Sunnica Ltd
2 Crossways Business Centre
Bicester Road
Aylesbury
HP18 0RA

21st January 2022

Application for a Development Consent Order for Sunnica Energy Farm

RE: Advice following issue of decision to accept the application for examination

AECOM  
 Unit 1 Wellbrook Court,  
 Gilton,  
 Cambridge, CB3 0NA  
 United Kingdom  
 Telephone (01223) 488000  
 www.aecom.com

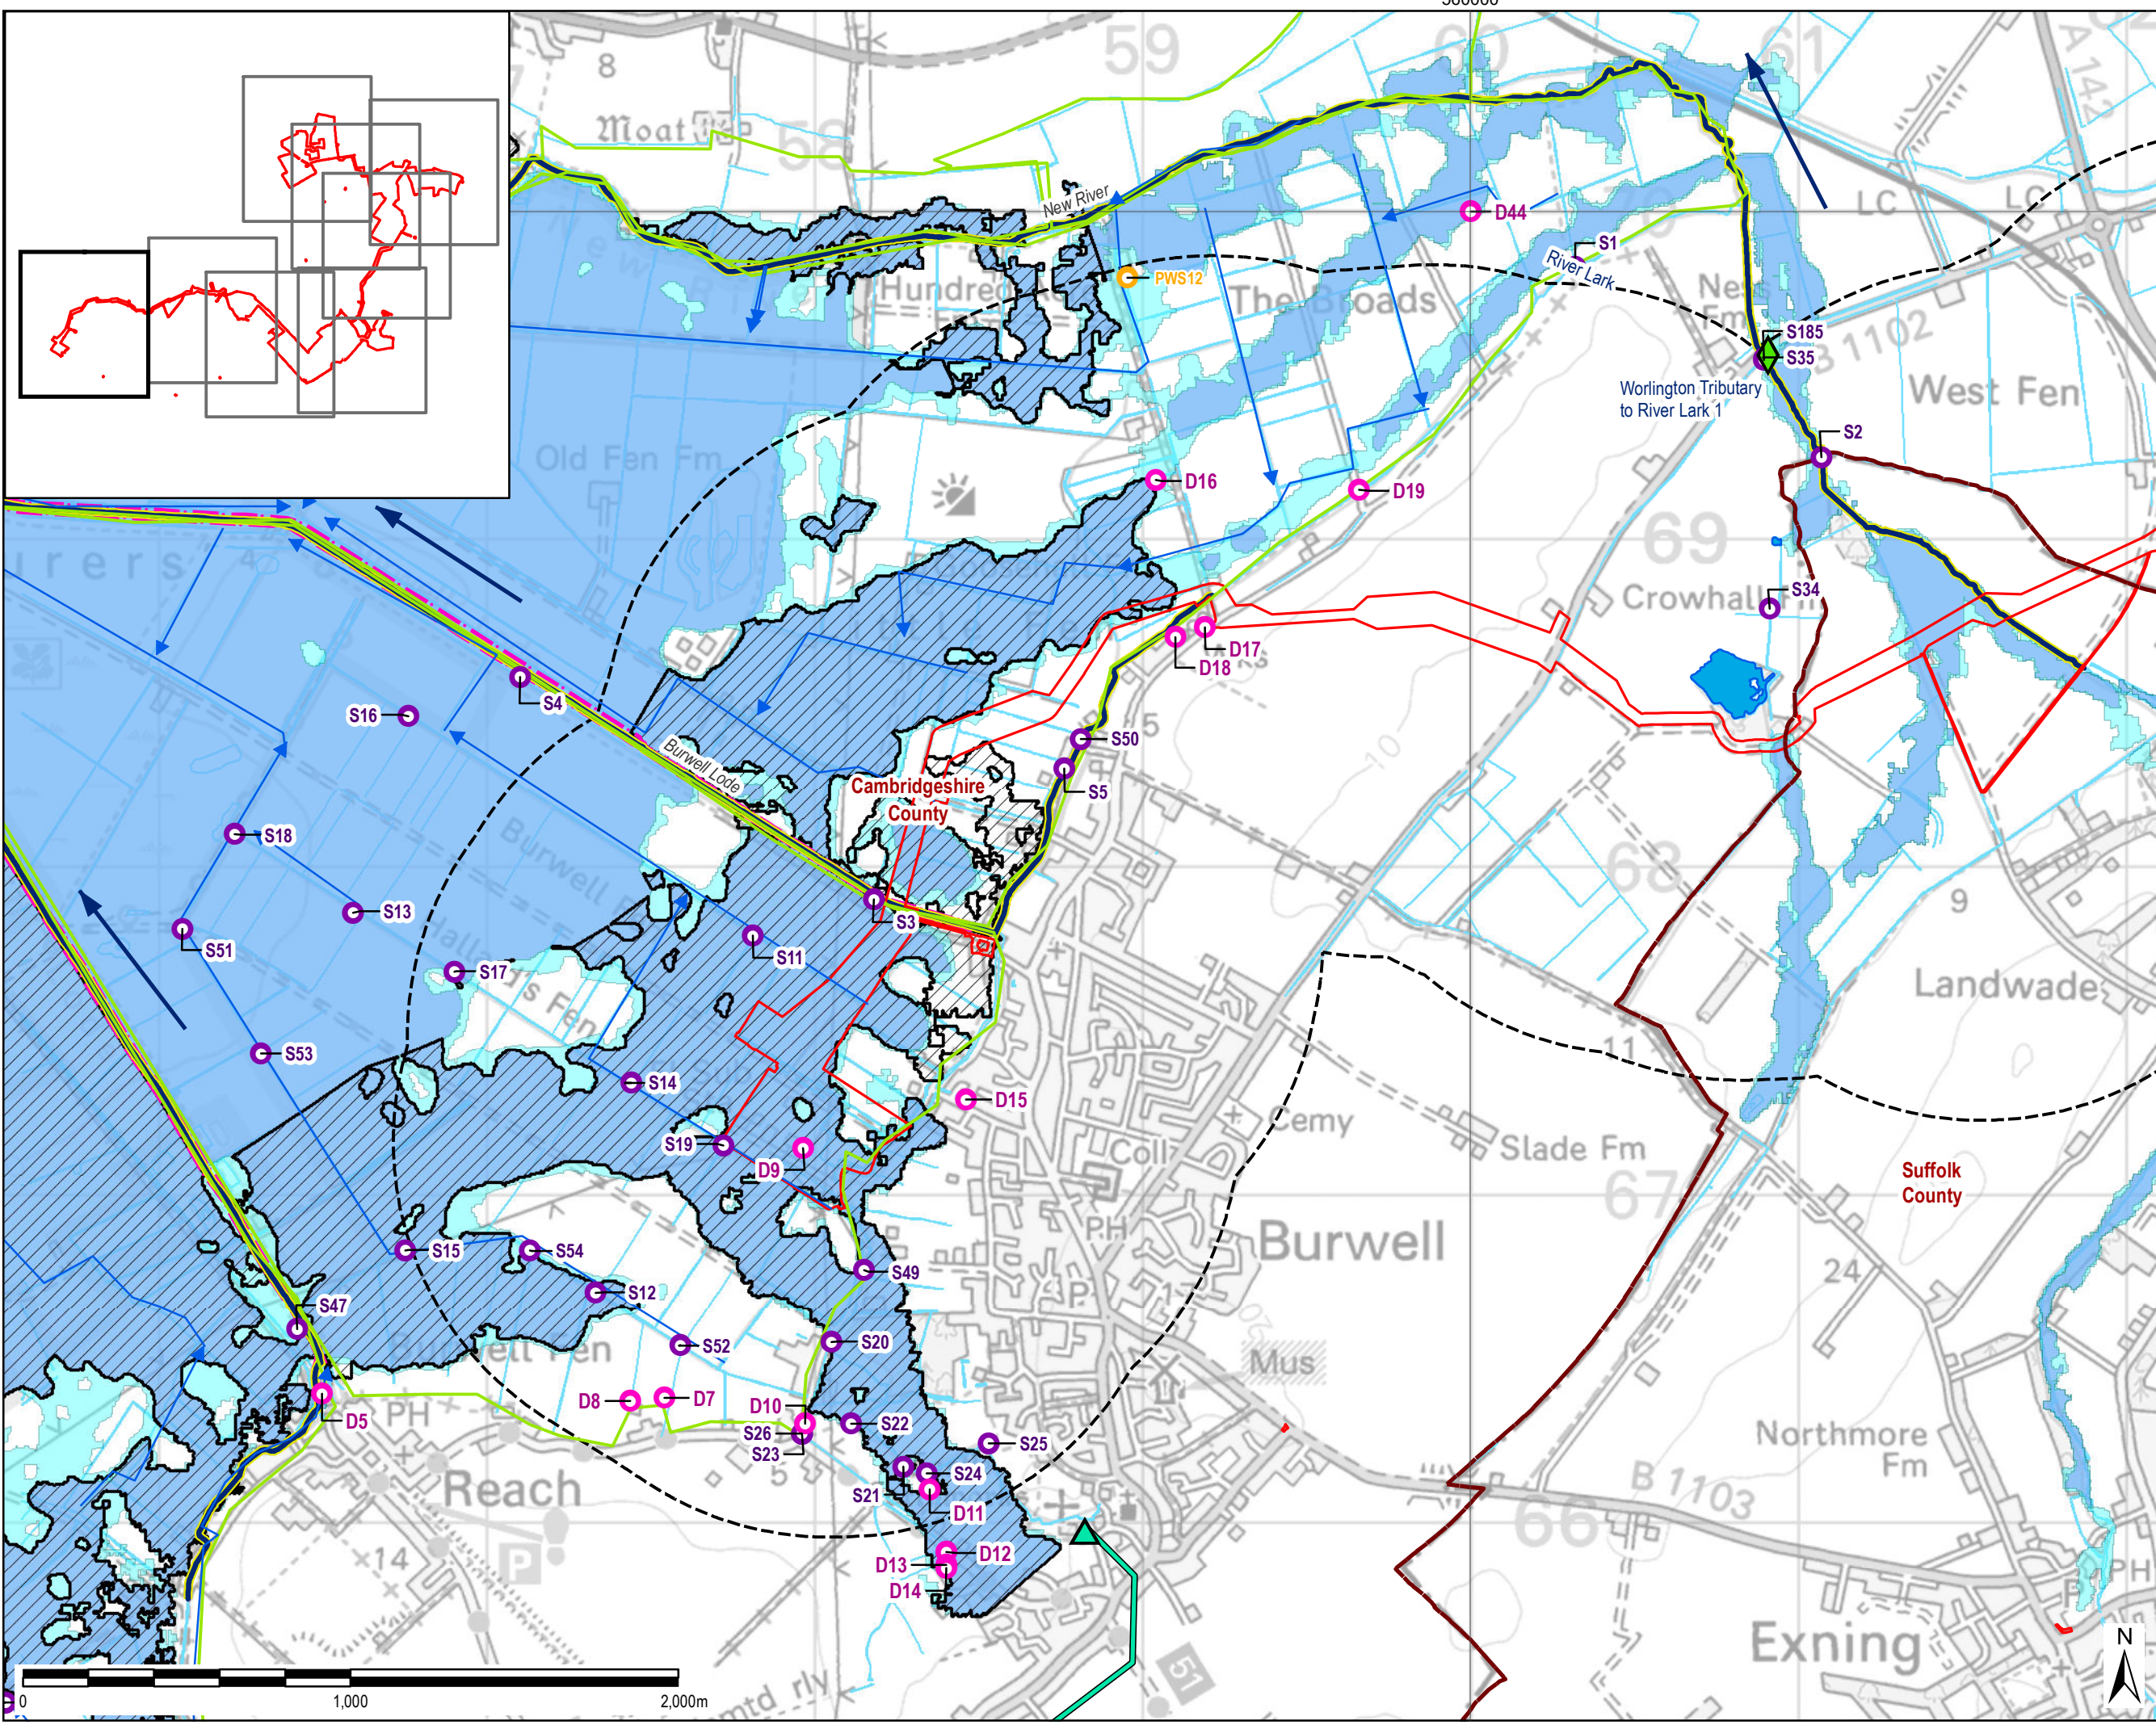
- 1.4.3 Revision 1 of Figure 9-1 of the Environmental Statement [APP-188] is provided to address the advice provided by the Planning Inspectorate.
